From: Emma Kirkman
Sent: Thursday, 6 December 2018 3:22 PM
To: Scott Hay
Cc: Media Hakim
Subject: SSD 9210 Saints Peter and Paul Assyrian Primary School EIS

On 5 November 2018, the Department of Planning and Environment invited GANSW to review and provide comment on the development application, including the Environmental Impact Statement, for the Saints Peter and Paul Assyrian Primary School. The project was presented to the SDRP on 13 June and again on 11 July. The outcomes of these reviews were incorporated in design advice provided to the proponent. The review of the EIS is made in relation to that advice. We remain supportive of the proposal, subject to additional comments below.

02 Section
A352 Roof Connection
Scale 1:50

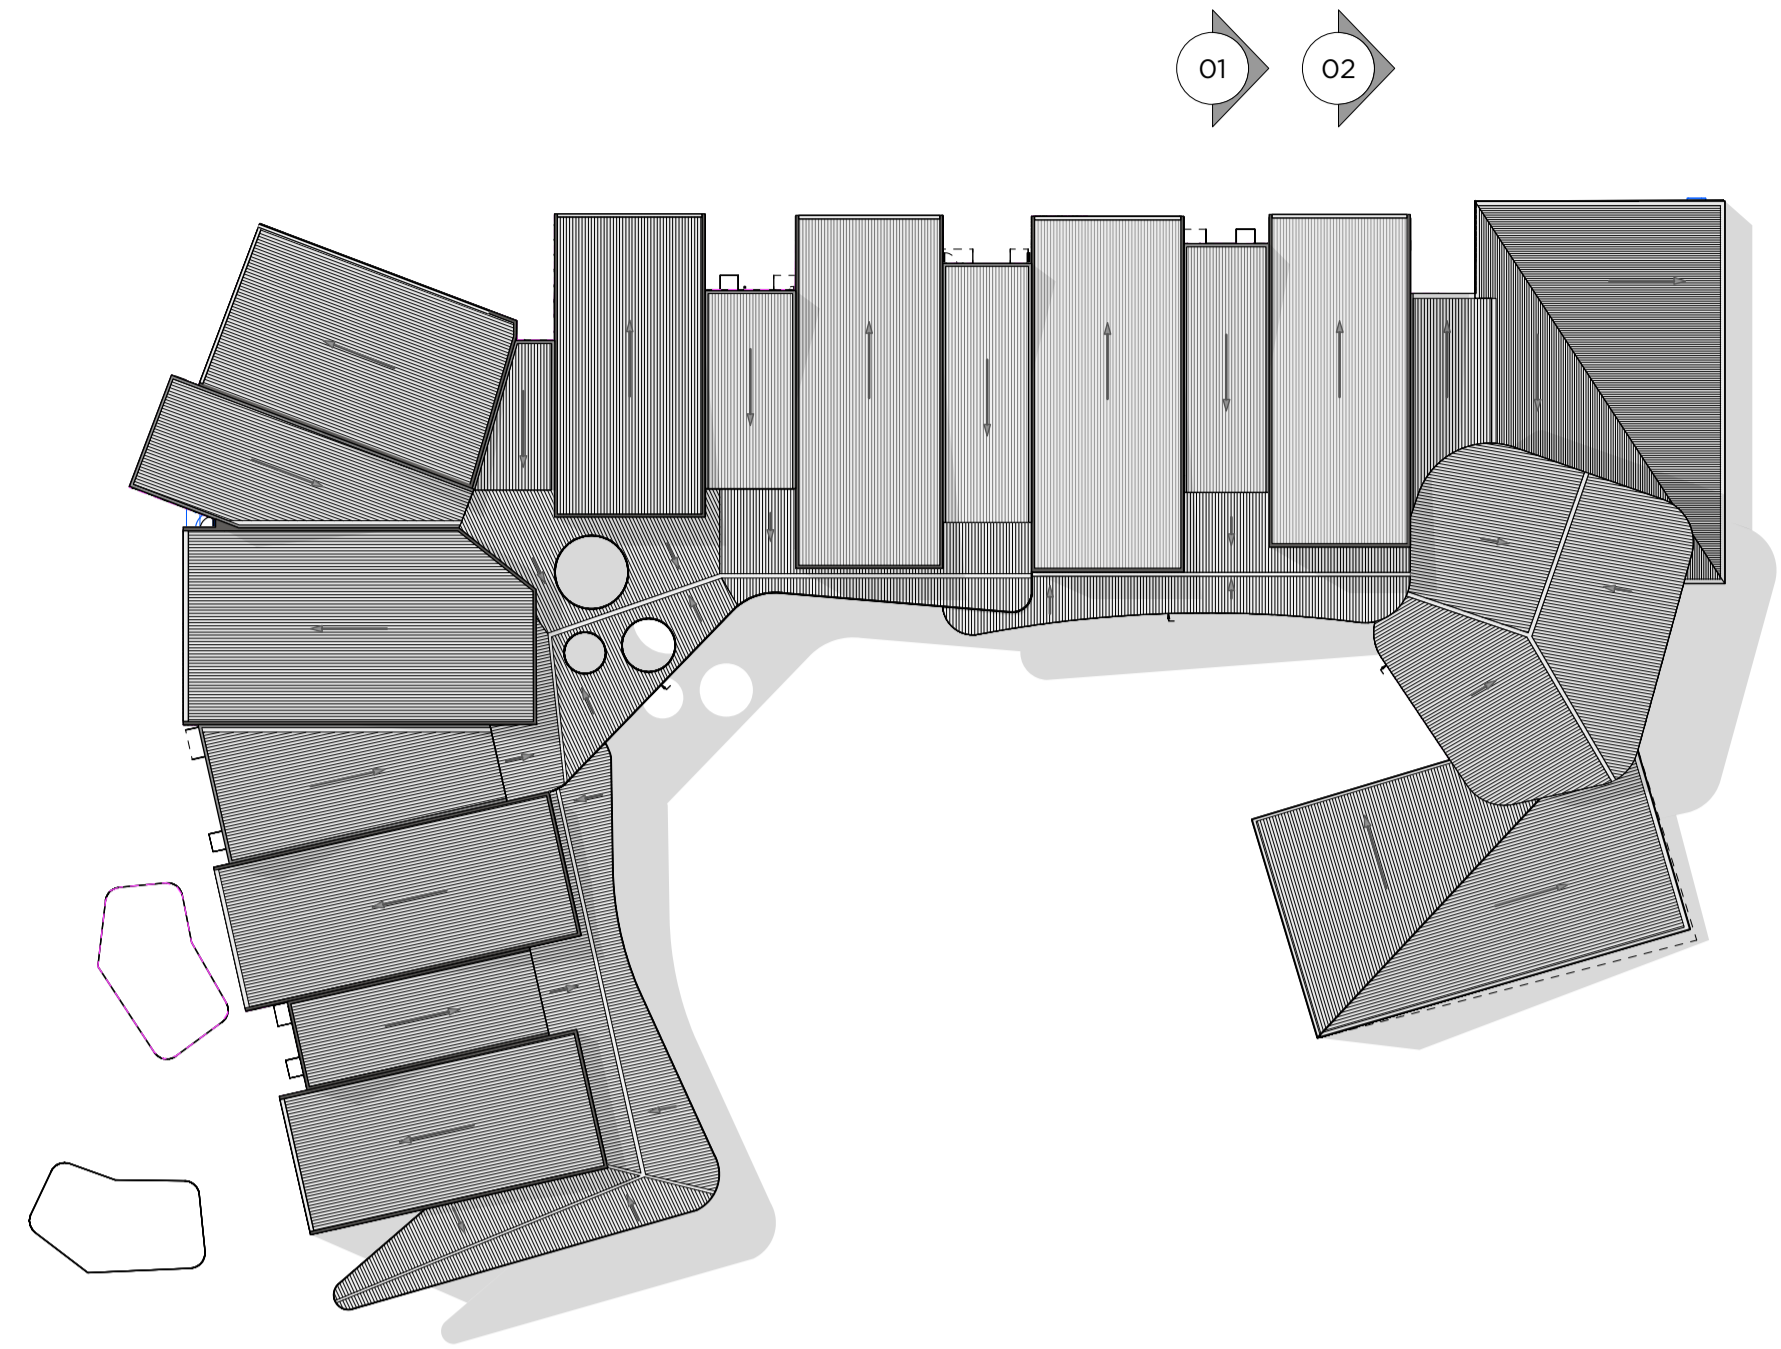
- While the design report states that solar and glare controls have been integrated into the façade design, we request larger scale drawings which show what these controls are and where they're used on the façade.
- We recommend larger scale drawings showing the detailed resolution of the skillion roof form, and heights and relationship to buildings of the canopy roof form.
